From: Amanda Scholes on behalf of Planning.Responses
Sent: 23 December 2020 08:35
To: Planning Scanning
Subject: FW: Planning Consultation on: WA/62/20/PL

Engineers comments in respect to surface water drainage;

Application No:	WA/62/20/PL
Registered:	5th November 2020
Site Address:	Lower Farm Yapton Lane Walberton BN18 0AS
Grid Reference:	498093 104586
Description of Works:	Construction of 5 hectares of glasshouses, a service area & a reservoir on agricultural land. This site is in CIL Zone 3 (Zero Rated) as other development.

TITLE Proposed Drainage Strategy Plan			
SCALE 1:1000 @ A3	PROJECT No. 23375		
REPORT TYPE FRA	DRG. No. 05

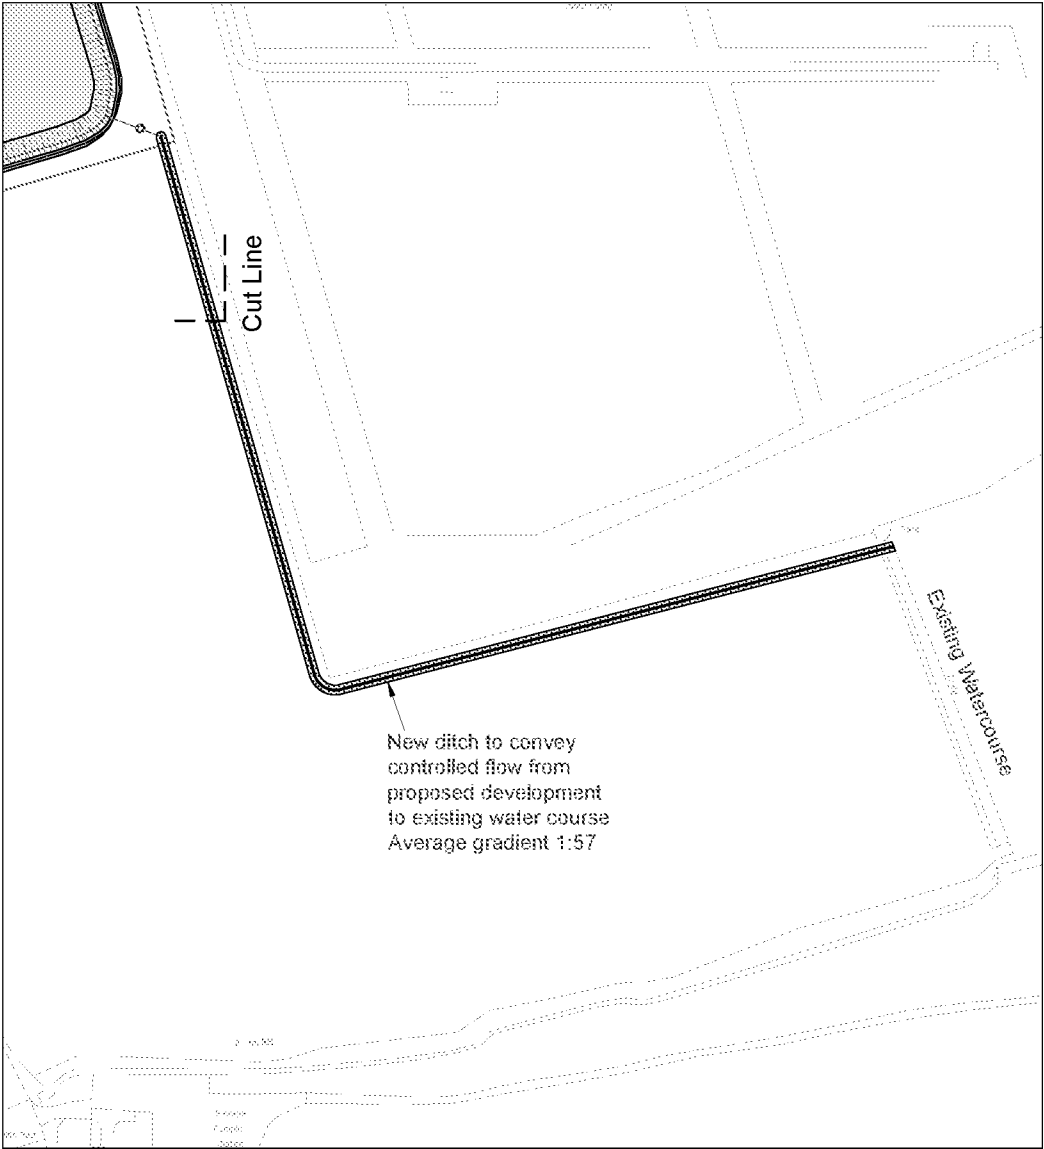
It is noted that the applicant proposes to discharge surface water runoff from the proposed development into a reservoir for water recycling purposes (ie. irrigation). The proposal will also incorporate a controlled outflow to the existing watercourse. No infiltration to ground is proposed which is considered reasonable for this proposal. However, it is noted that winter groundwater monitoring is proposed – this will help inform the design of the reservoir, etc.

The applicant should note that discharge rate from the reservoir must be restricted to at least Q_{bar} . There may be a discrepancy within the Flood Risk Assessment in terms of the calculated Q_{bar} rate and the controlled outflow rate from the reservoir, so this will need to be discussed. The inlet into the reservoir will also need to be designed against a surcharged outfall. The construction of the proposed new ditch providing connectivity from the reservoir to the existing watercourse must not increase flows downstream ie. needs to account for potential groundwater and surface water run-off from the surrounding land.

Land drainage consent is required for the new ditch and the culverting of any ditches to facilitate vehicular access.

A distance of at least 3 metres must be achieved between the top of the bank of any watercourse/ditch and any proposed structure. This appears to be not being achieved, so there will need to be some tweaking to the layout ie. the cycle shelter, tanks, etc.
